Heckington Fen Solar Park

EN010123

Statement of Common Ground with Natural England

Document Reference: 7.6i

| Condense / Sho | ow Columns Cond | ment Idense / Show Rows Instructions | | | | | | | | | | | | | | | | | | | Change in broad | d habitat type dete | cted. Check compliance with guidance. | | | | | | | |

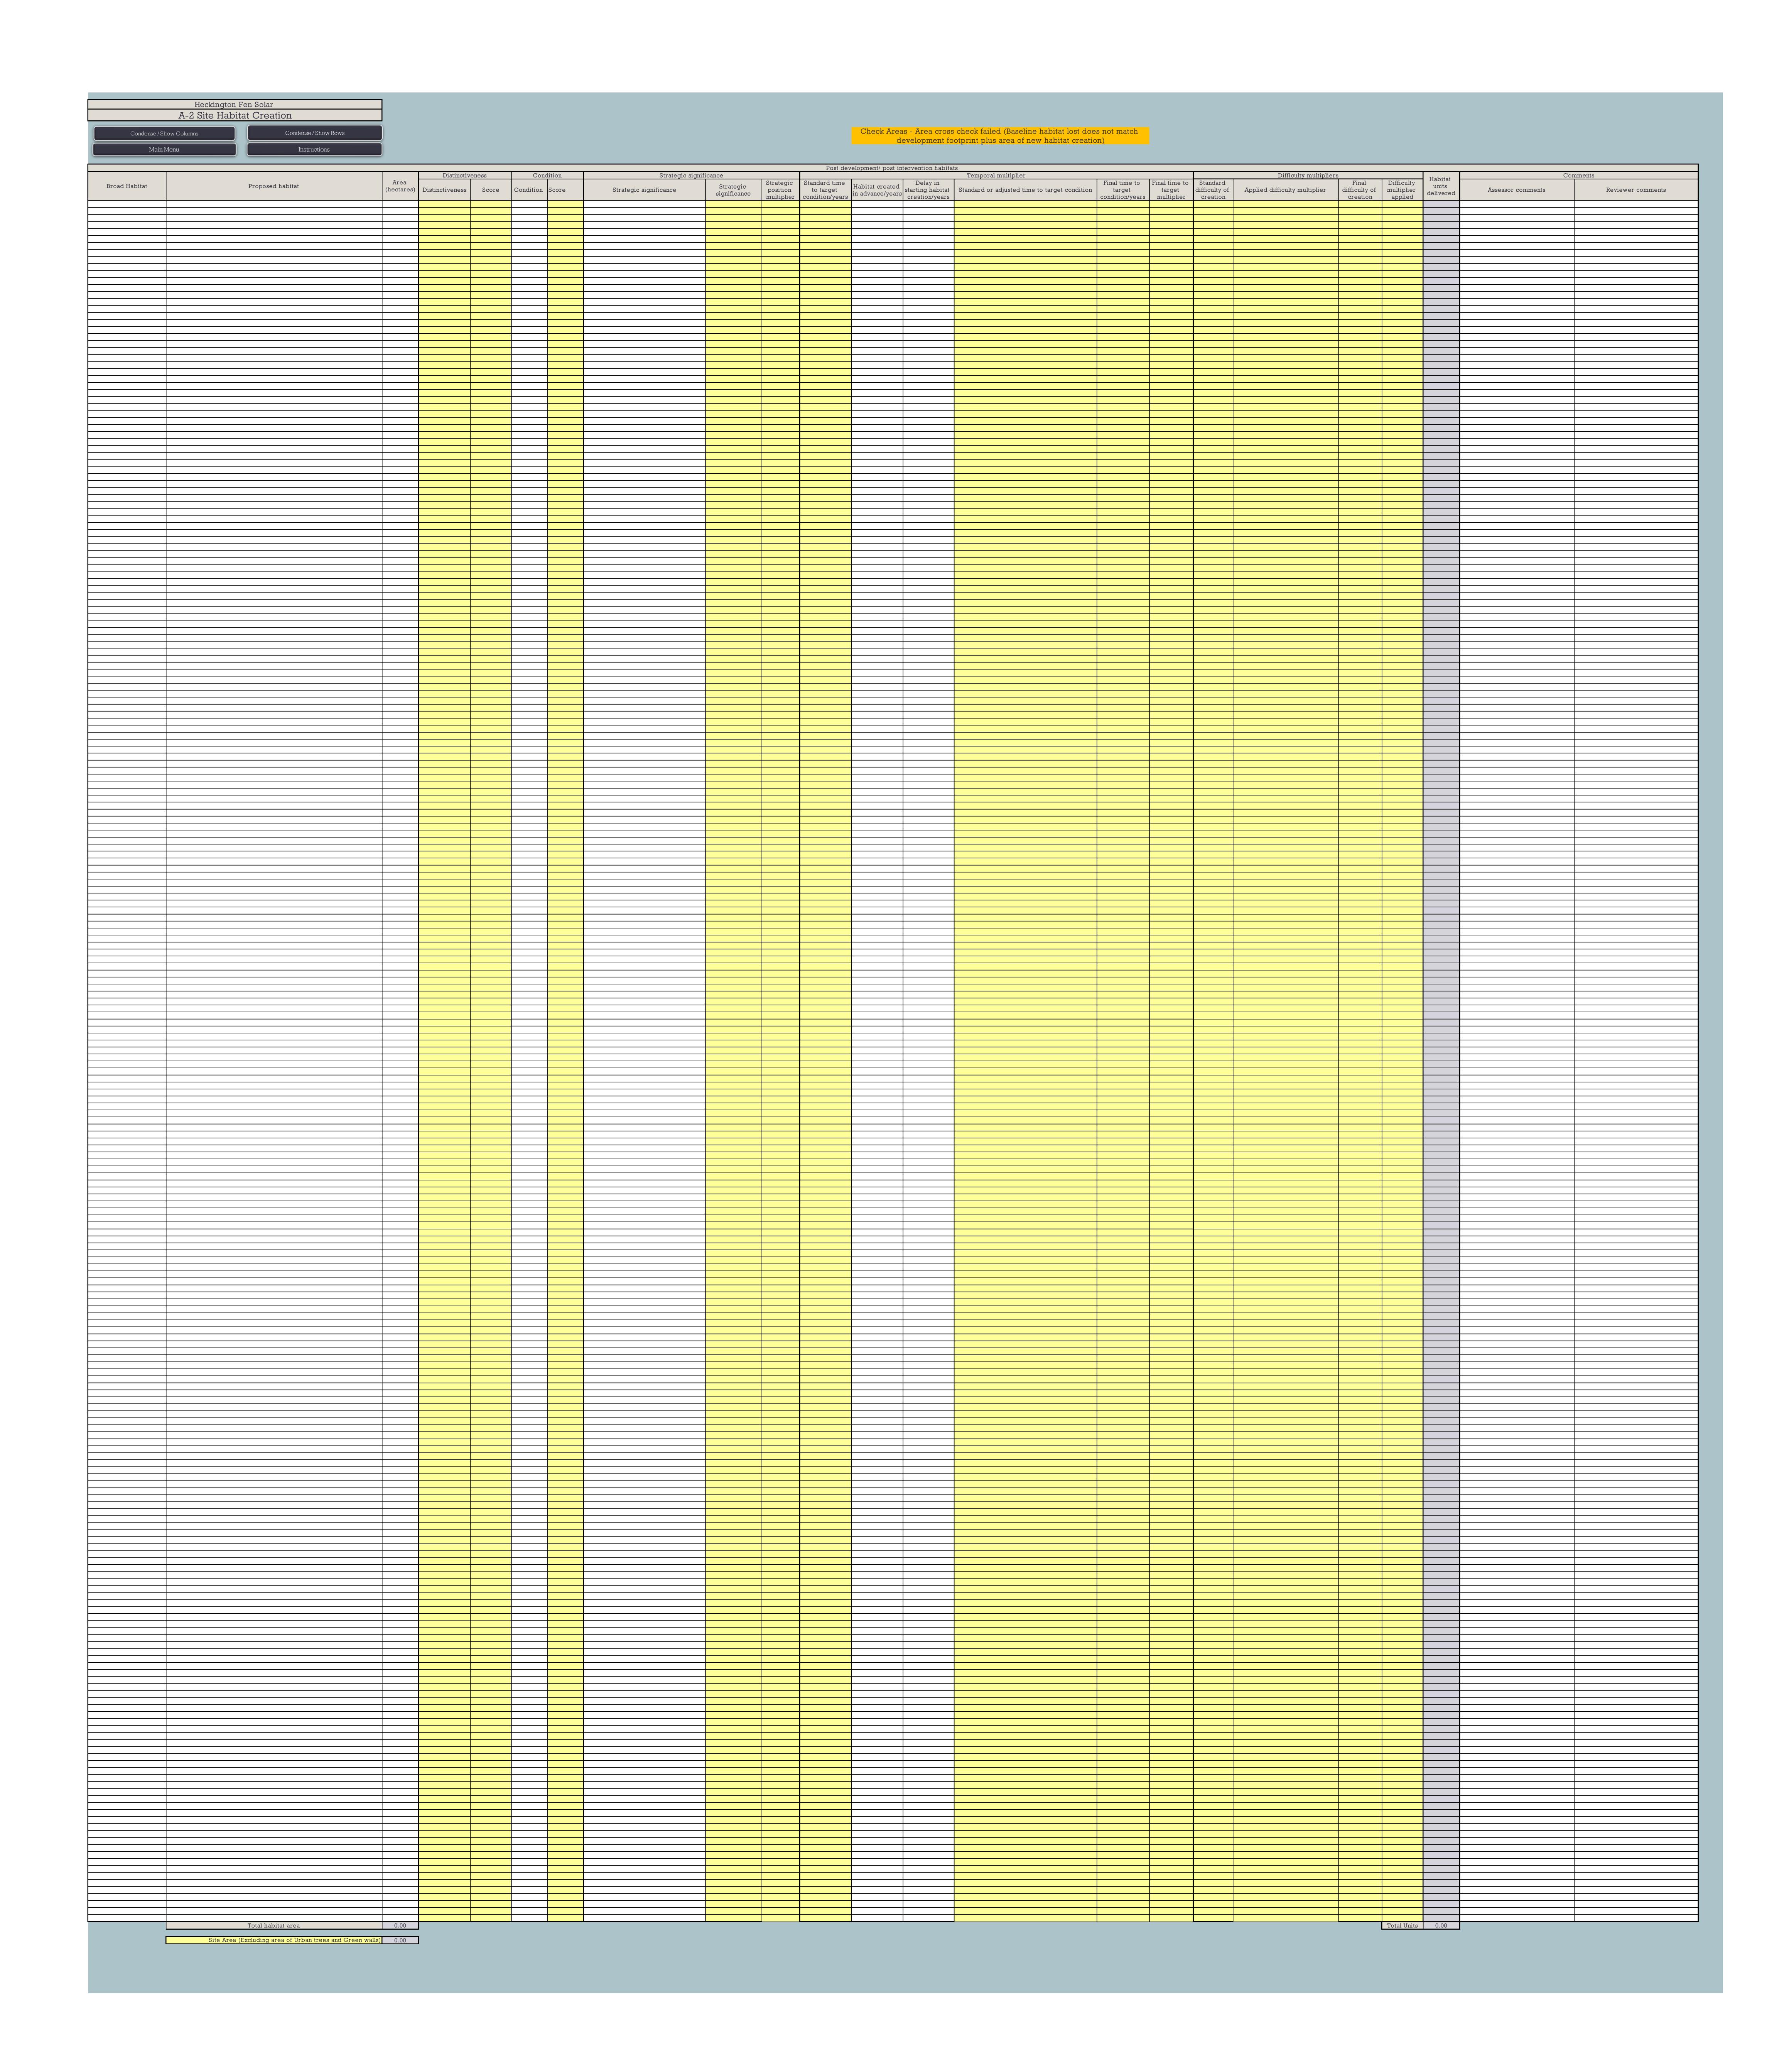
Reference and Status	Topic	NE's Position	Applicant's Position
6. Biodiversity Net Gain			
6.1 Agreed	Biodiversity Net Gain Metric 3.1 used (Appendix 8.12) provided to NE on 20 th June 2023.	NE welcomes the commitment to deliver BNG and is generally supportive of the enhancements proposed through the development. The enhancements detailed within the oLEMP, are welcomed and are likely to indirectly have a positive effect.	The Applicant notes NE's comments made in relation to BNG during consultation which are generally supportive of the enhancements proposed, and detailed in the oLEMP.
